P/33/26/DOC

Little Welbourne Church Lane Pagham PO21 4NX

Approval of details reserved by condition under P/2/23/L relating to condition 3 (1.)- Windows & Doors.

CLIENT'S NAME  
**Mr & Mrs Bell**  
JOB TITLE  
**Little Welbourne  
Pagham**  
DRAWING TITLE  
**Proposed Window / Door Schedule**

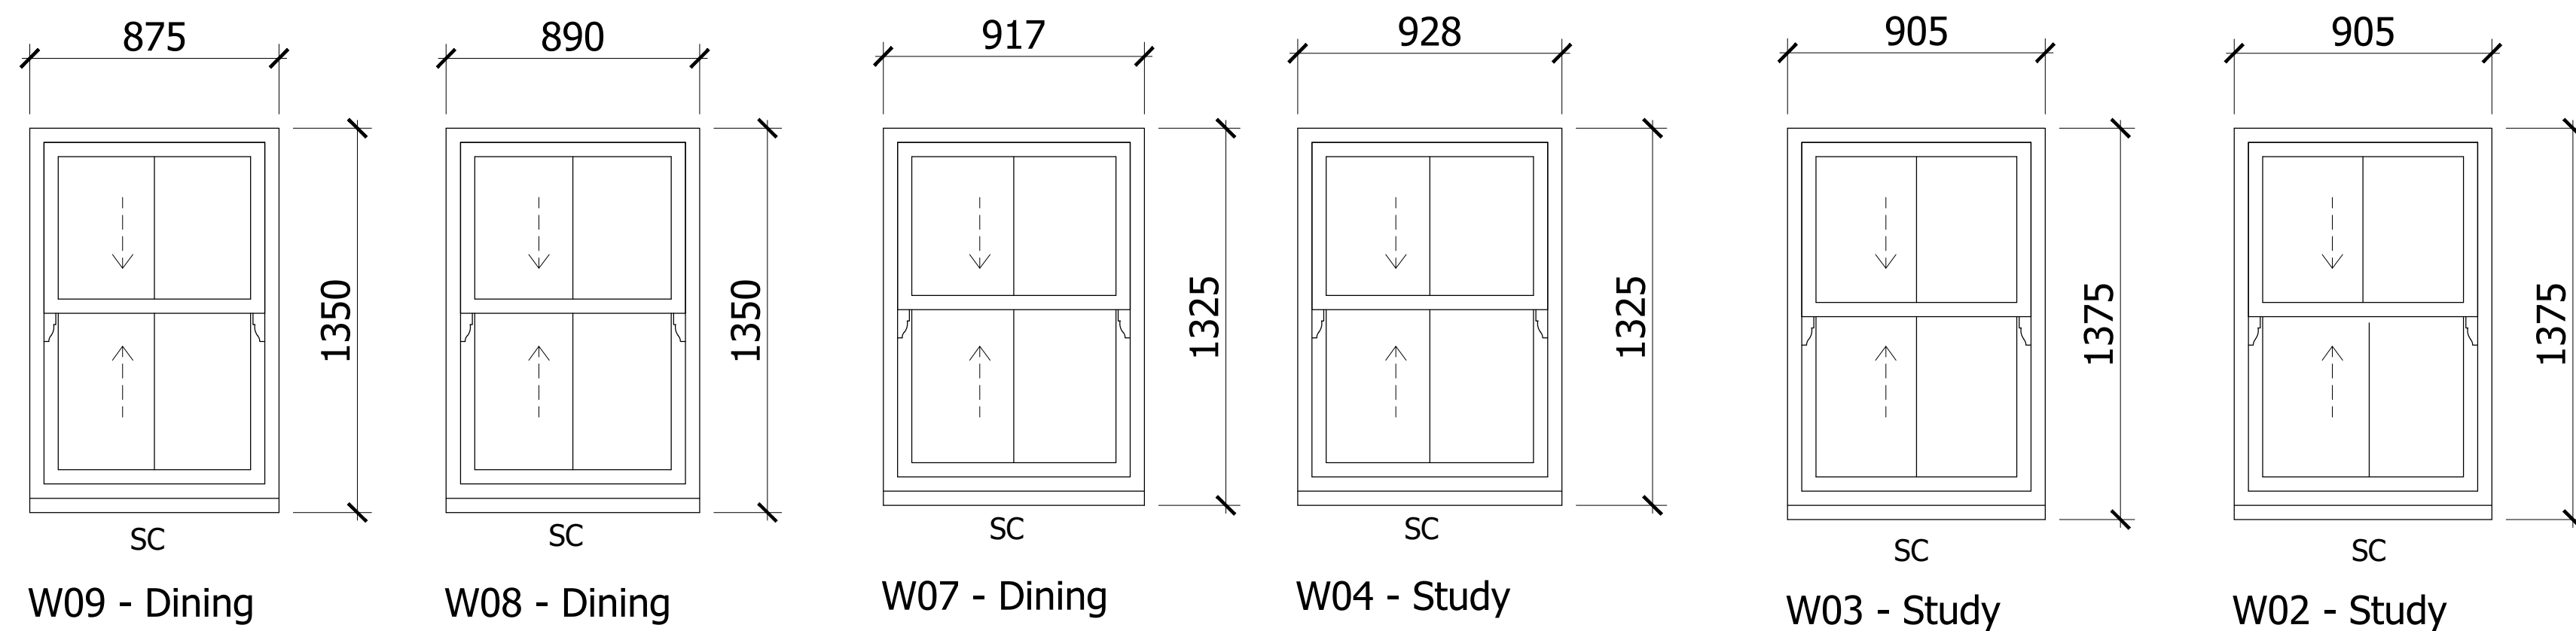
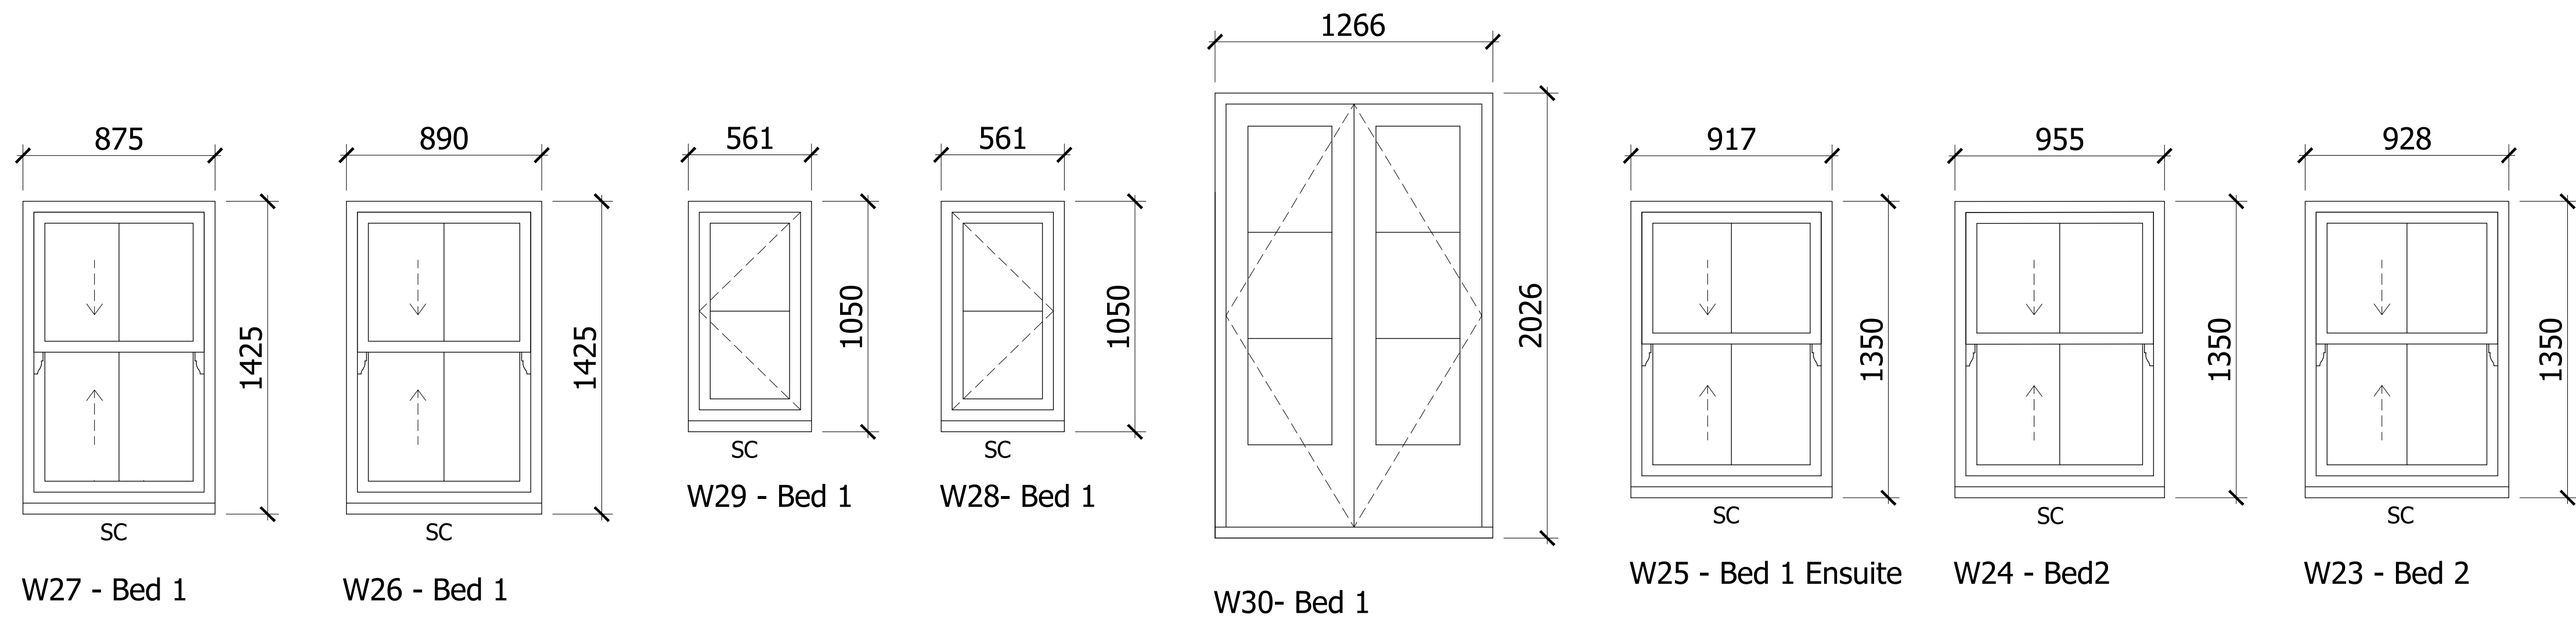
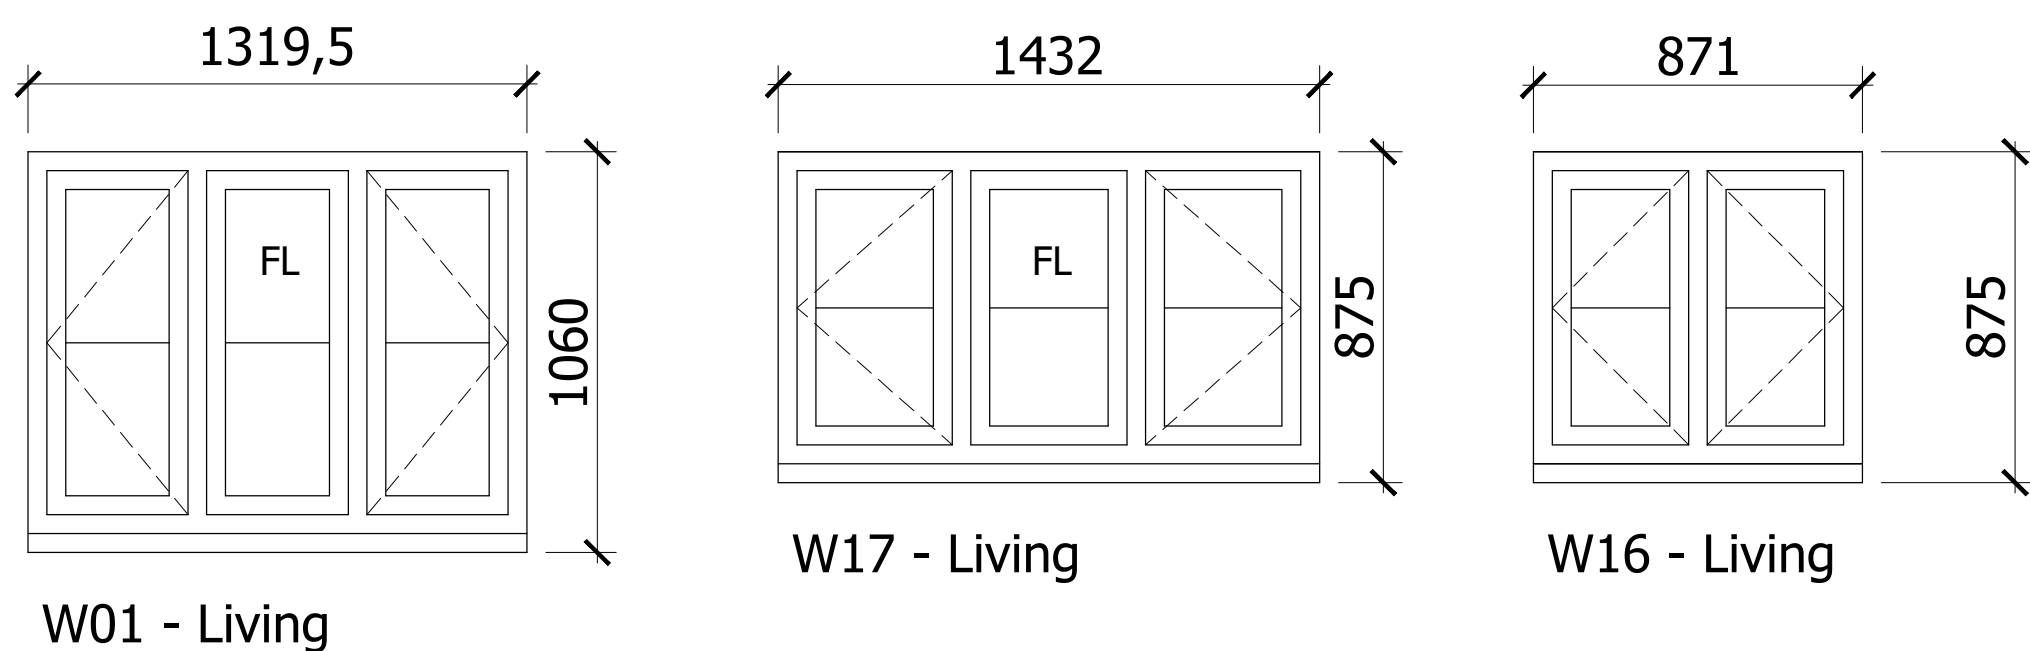
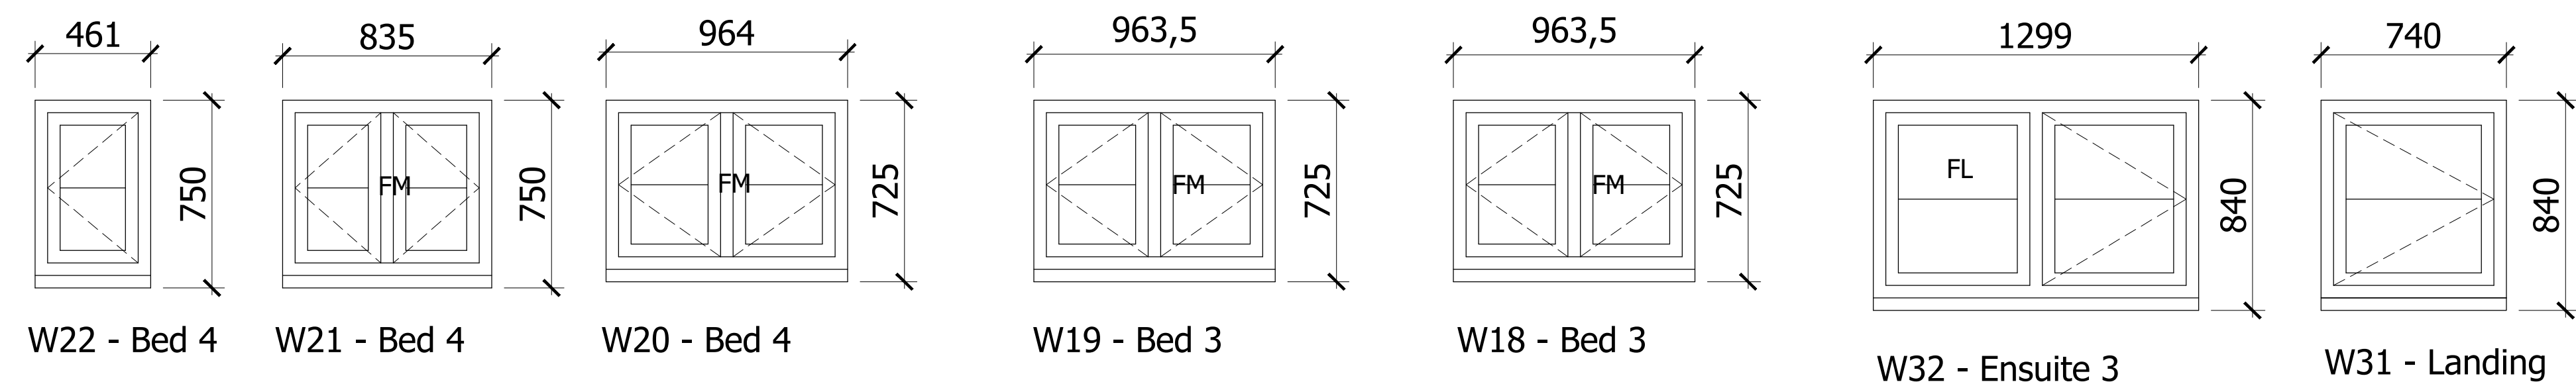
The French doors are acceptable in principle, however the glazing bars are overly thick and would appear visually heavy and dominant within the openings. This would not be appropriate, particularly if repeated across the building, and slimmer glazing bar sections are required. The overall joinery is also on the heavy side, although the primary concern relates to the glazing bar thickness.
